**Subject: Request for Modification to the Section 404 Individual Permit and Section 401 Water Quality Certification for I-485 (Charlotte Outer Loop) from east of I-77 to I-85 in Mecklenburg County. Division 10, TIP's R-2248 E and R-2123 CE, Debit \$570 from WBS 34410.3.GV2**

**Reference: USACE Individual Permit Action ID SAW-2011-01237, dated Nov.22, 2011.  
NCDWQ Water Quality Certification No. 003868, dated October 14, 2011.**

**R-2248 E – Roadway Portion of Future I-485 between I-85 and NC 115**

FILE: R:\in\04\12248E\Hydraulics\PERMITS\_Environmental\Drawings\Revised\Permit\Drawings\December 2011\12248E\_RDP\_ASH\_20B\_SHE 13.DGN  
 DATE: 3/27/2012 4:35:59 PM

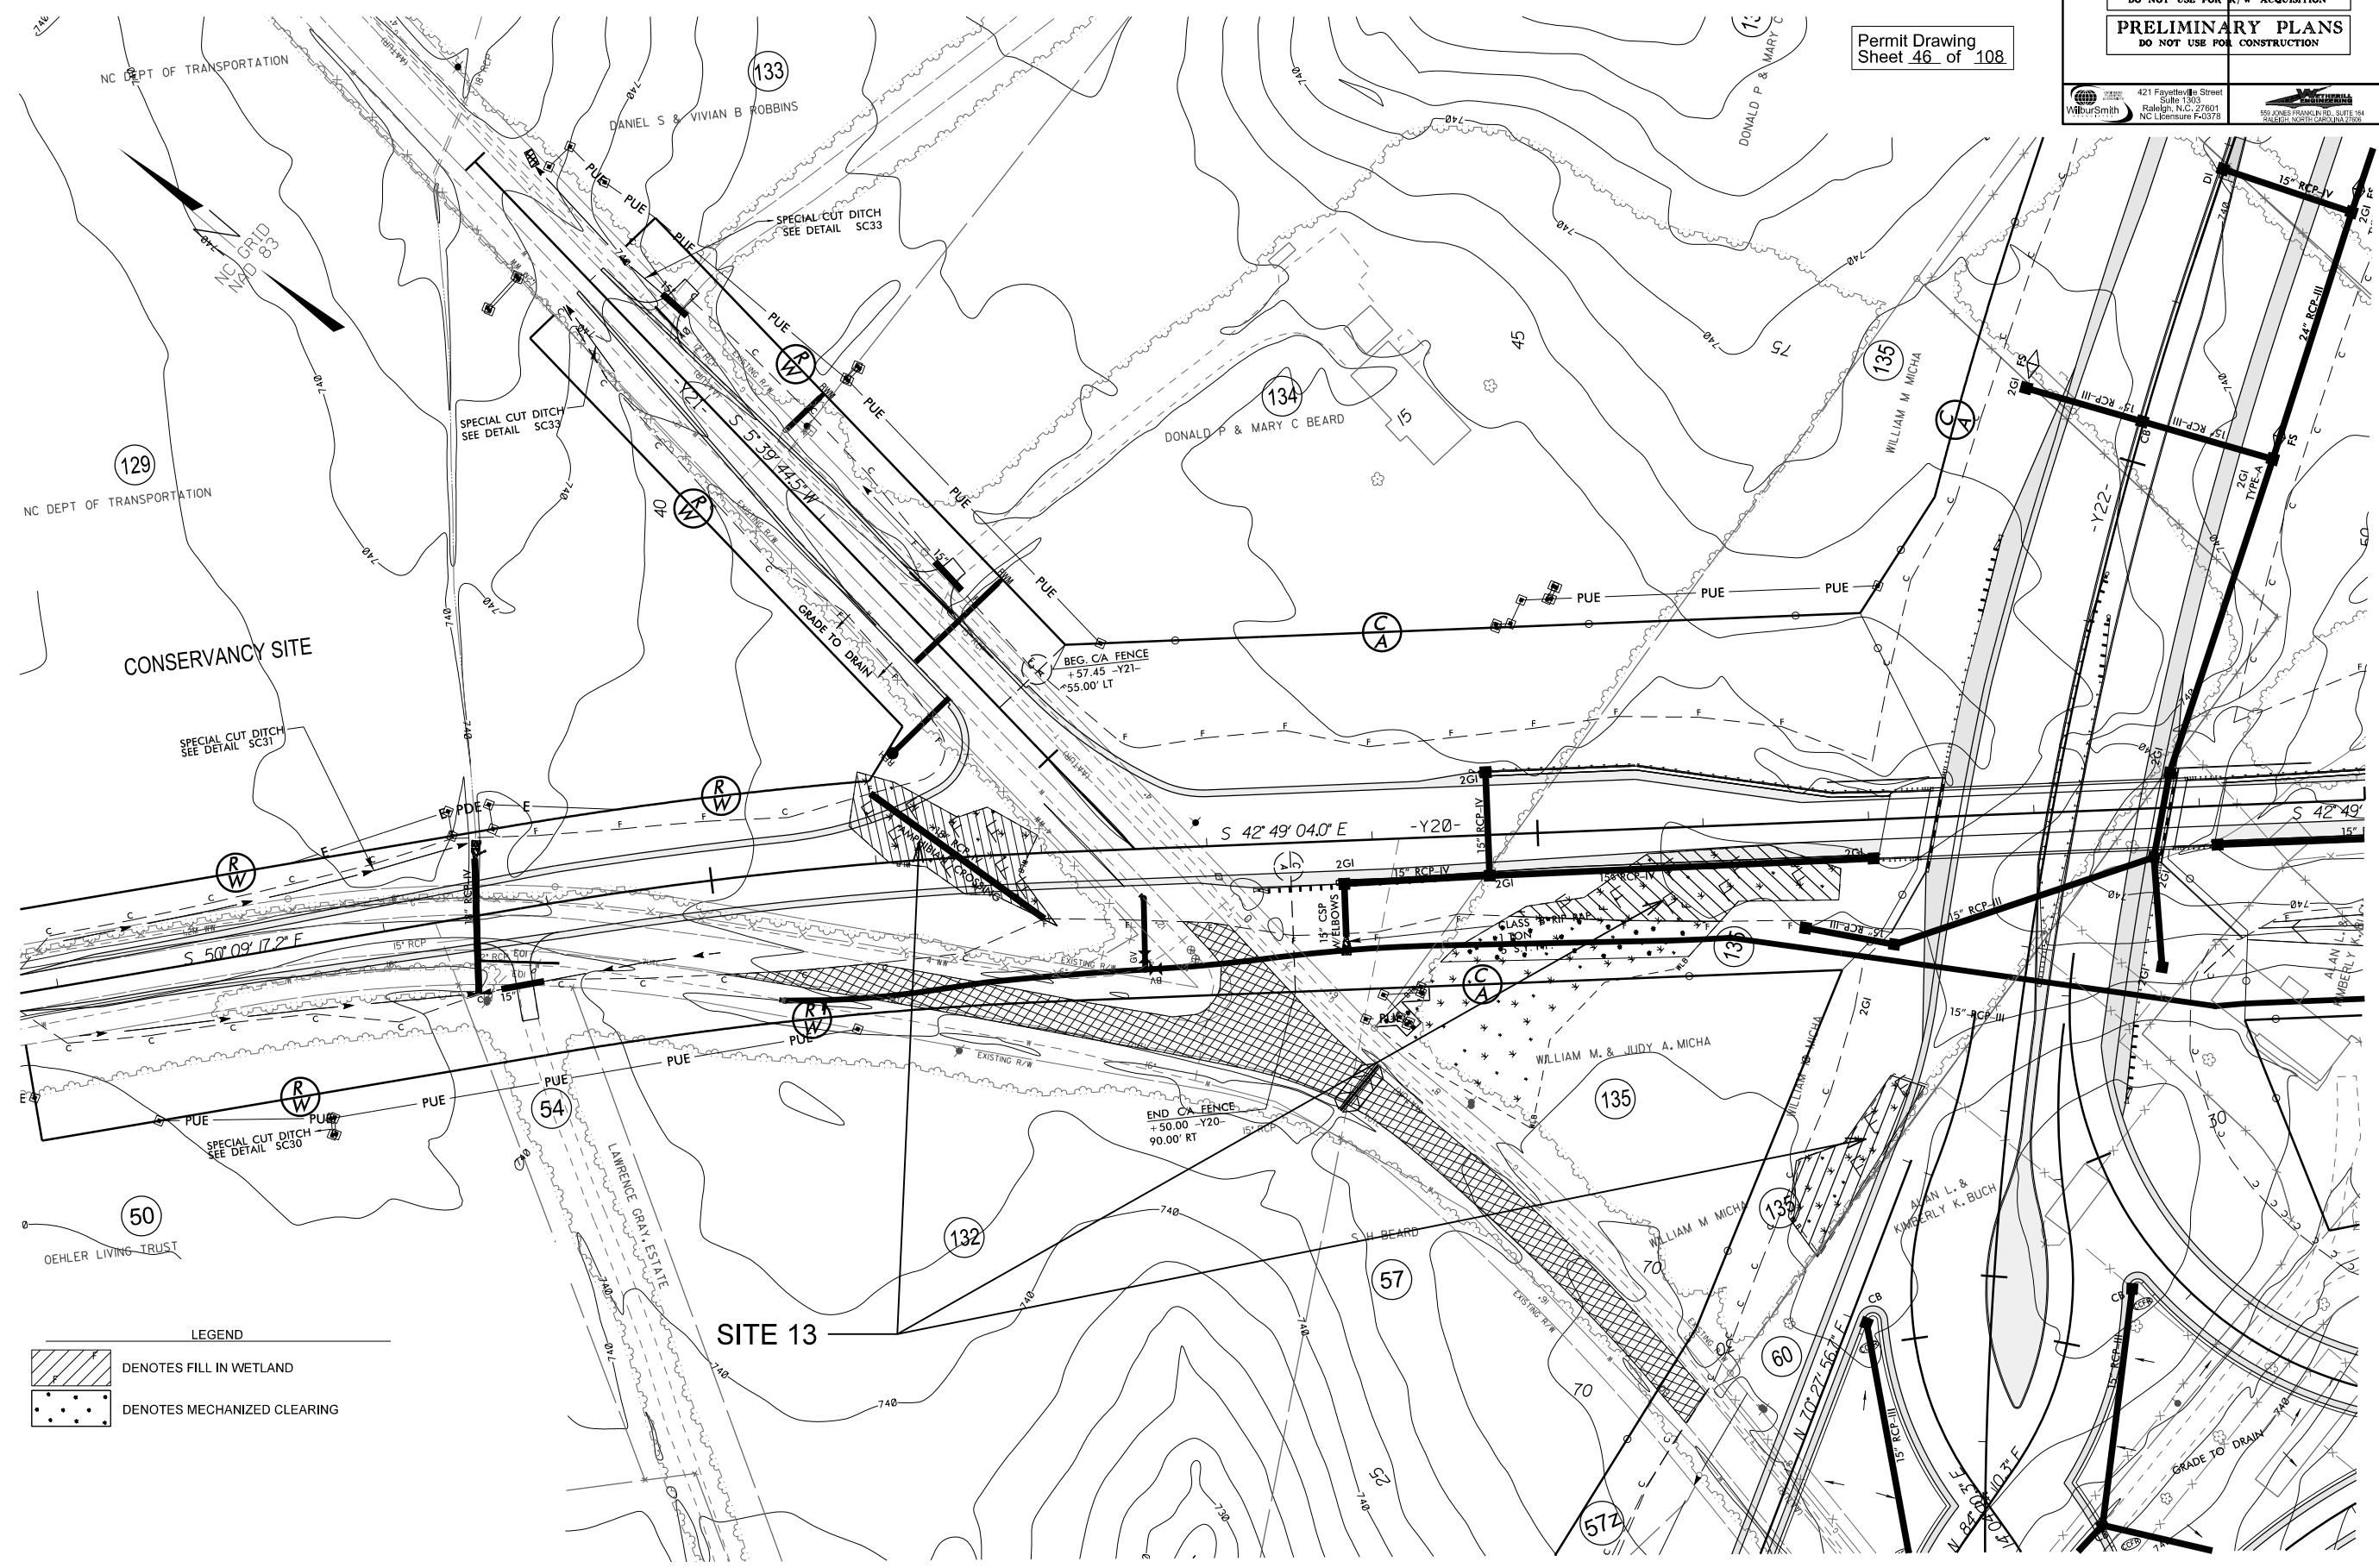
**Revision:** A new water line will cross portions of wetland WO. Utility pole guy-wire anchors will also result in impacts to wetland WO.

**Reason:** Water line and utility pole guy-wire anchors added, south of Y22.

**Impacts:** Impacts to wetlands WL and WP have not changed. The alignment of the water line was placed as close to the fill slope as possible, in order to minimize impacts to WO. Water line installation must occur prior to construction of Y20, which precludes placing the water line under the future fill slope.
